From: Anita Gardner <Anita.Gardner@arun.gov.uk>
Sent: 14 October 2020 08:42
To: Planning.Responses <Planning.Responses@arun.gov.uk>
Subject: FW: M/63/20/PL 46 Sea Lane, Middleton

From: Anita Gardner [<mailto:Anita.Gardner@arun.gov.uk>]
Sent: 08 October 2020 17:35
[REDACTED]
Subject: M/63/20/PL 46 Sea Lane, Middleton

Drawing No.:	Rev:
20-189-21	B

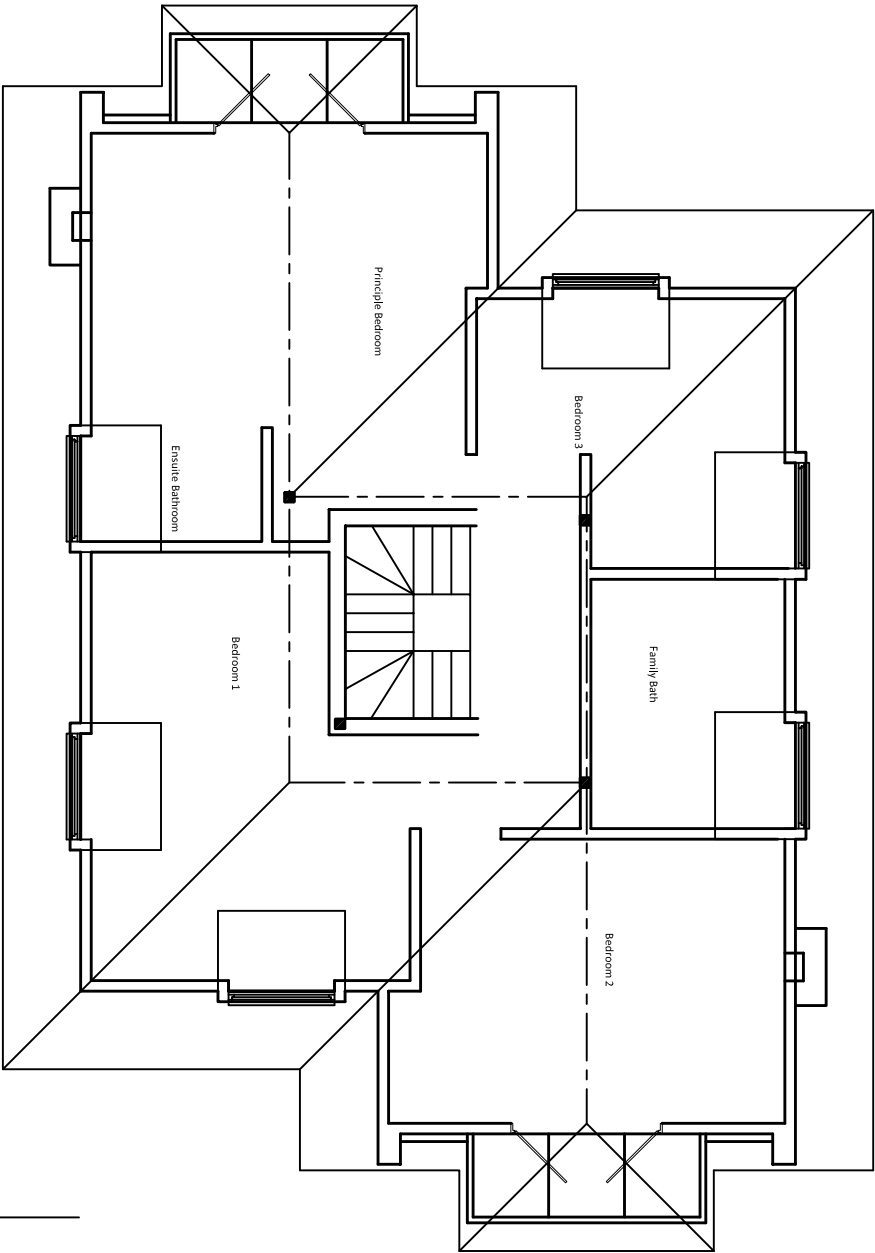
I have noticed that the submitted plans include changes to the first floor layout to create an additional bedroom which is not referred to in the description of the application I am seeking clarification as to whether the application will need to be re-advertised on this basis.

Whilst I do this can you confirm the gross internal floor area of the dwelling, the gross internal floor area of the proposed new bedroom, whether any additional parking provision is proposed and which of the approved plan numbers you are seeking to substitute with the proposed revisions. Having looked at the approved plans I believe that a revised roof and block plan will be required as part of this proposal.

The gross internal floor area is 221 m².

Drawn by:	Date:	Scale:
GW	OCT-20	As stated
Drawing/Cad Ref. No.:	20-189	
Drawing No.:	20-189-BP	Rev:

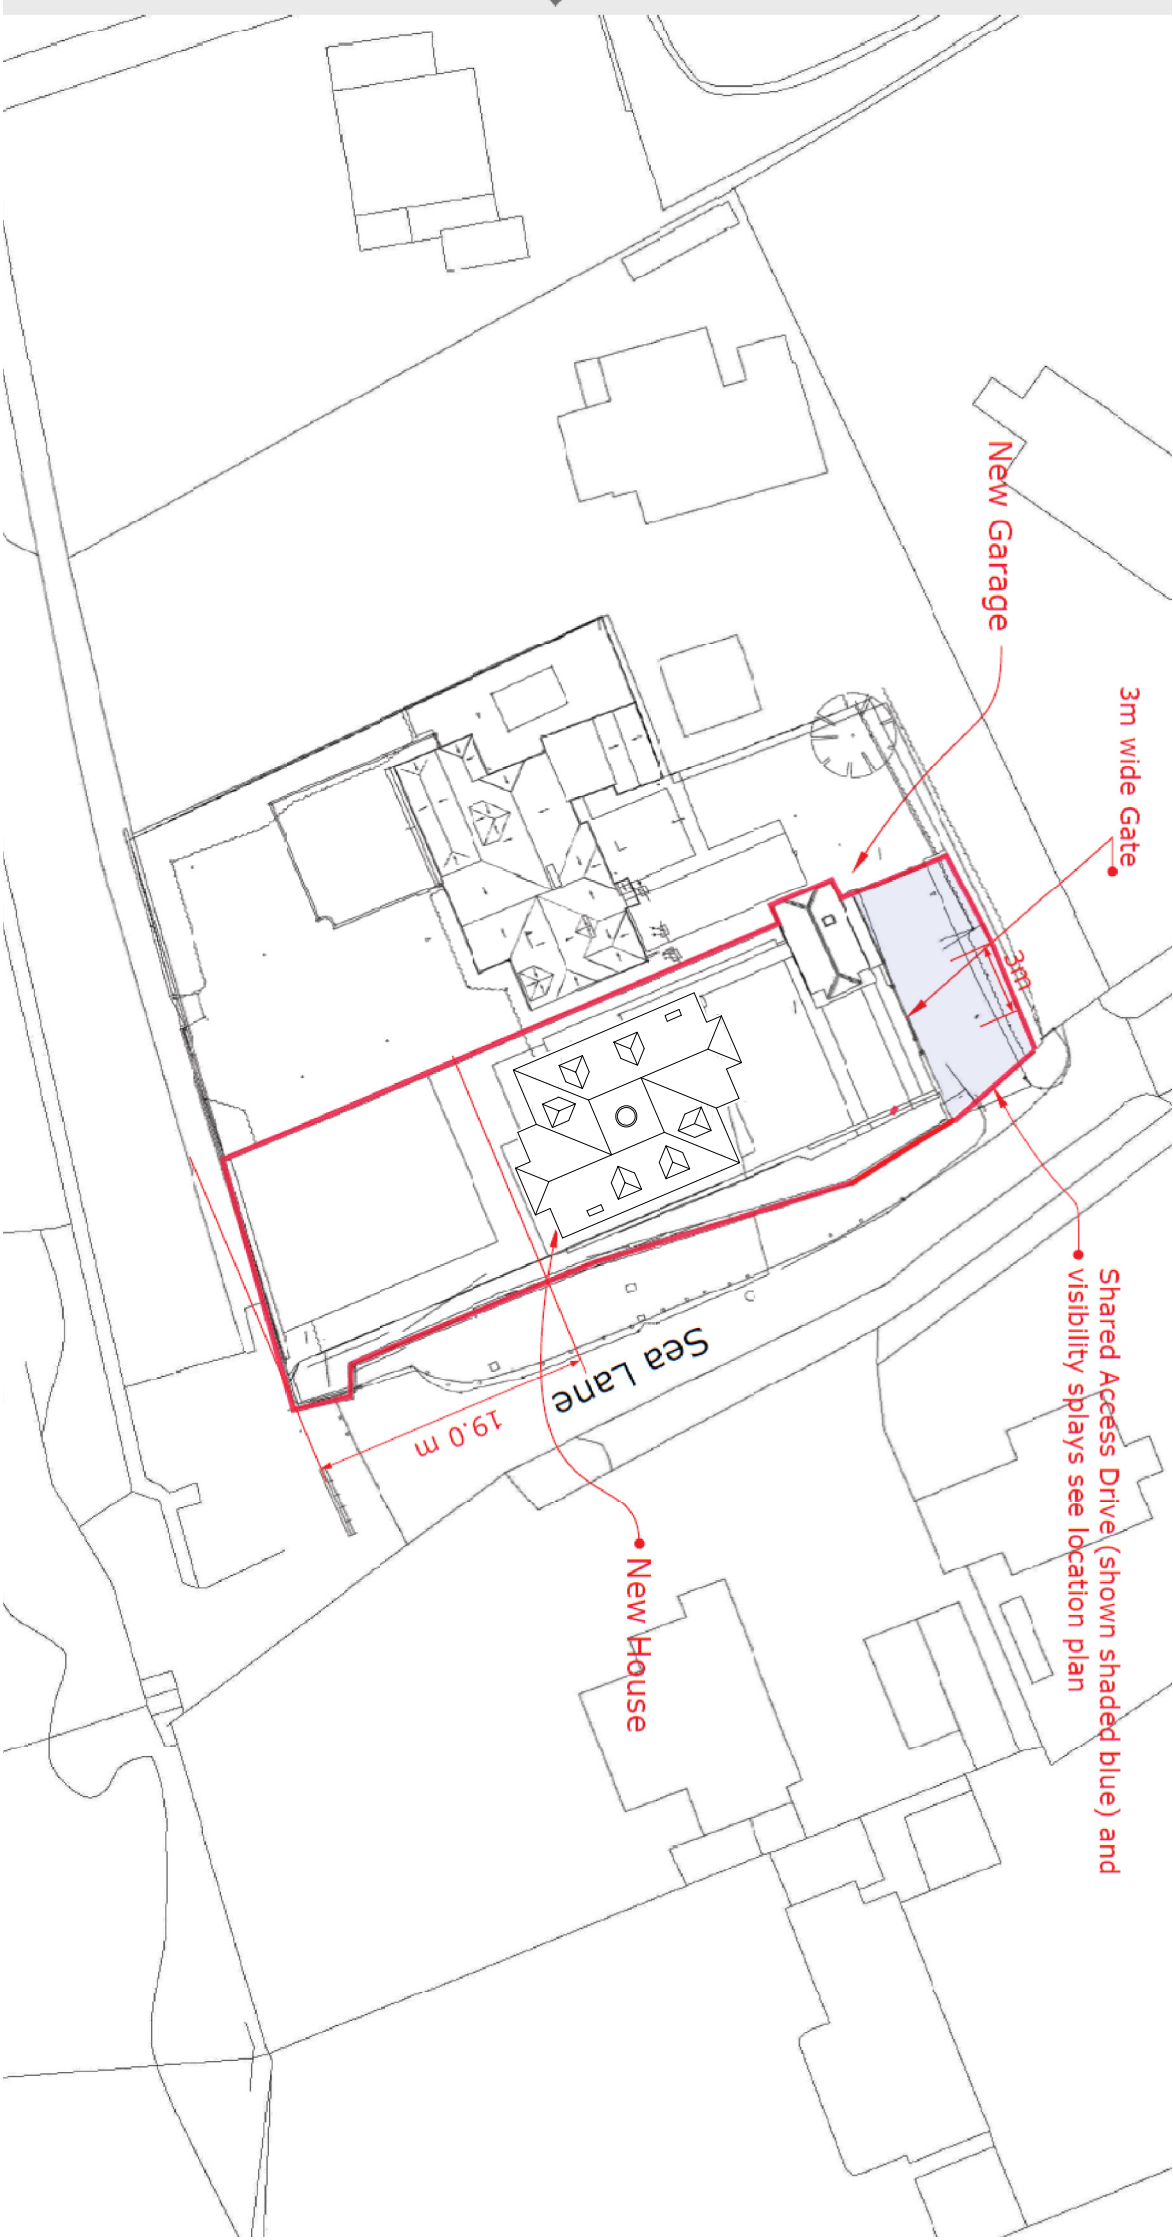
Can you also advise which of the original drawing numbers you are seeking to substitute and the gross internal floor area? With regard to car parking when Arun's parking standards are applied for parking Zone 2, which Middleton falls within, the parking requirements for a 3 bed and 4 bed dwelling increase by one space to 3 spaces. How many spaces were approved originally?

The original approval has 3 car parking spaces - this is to be maintained.

Please find attached a copy of the Roof Plan 20-189-202 and Block Plan drawing no. 20-189 BP with the appropriate amendments.
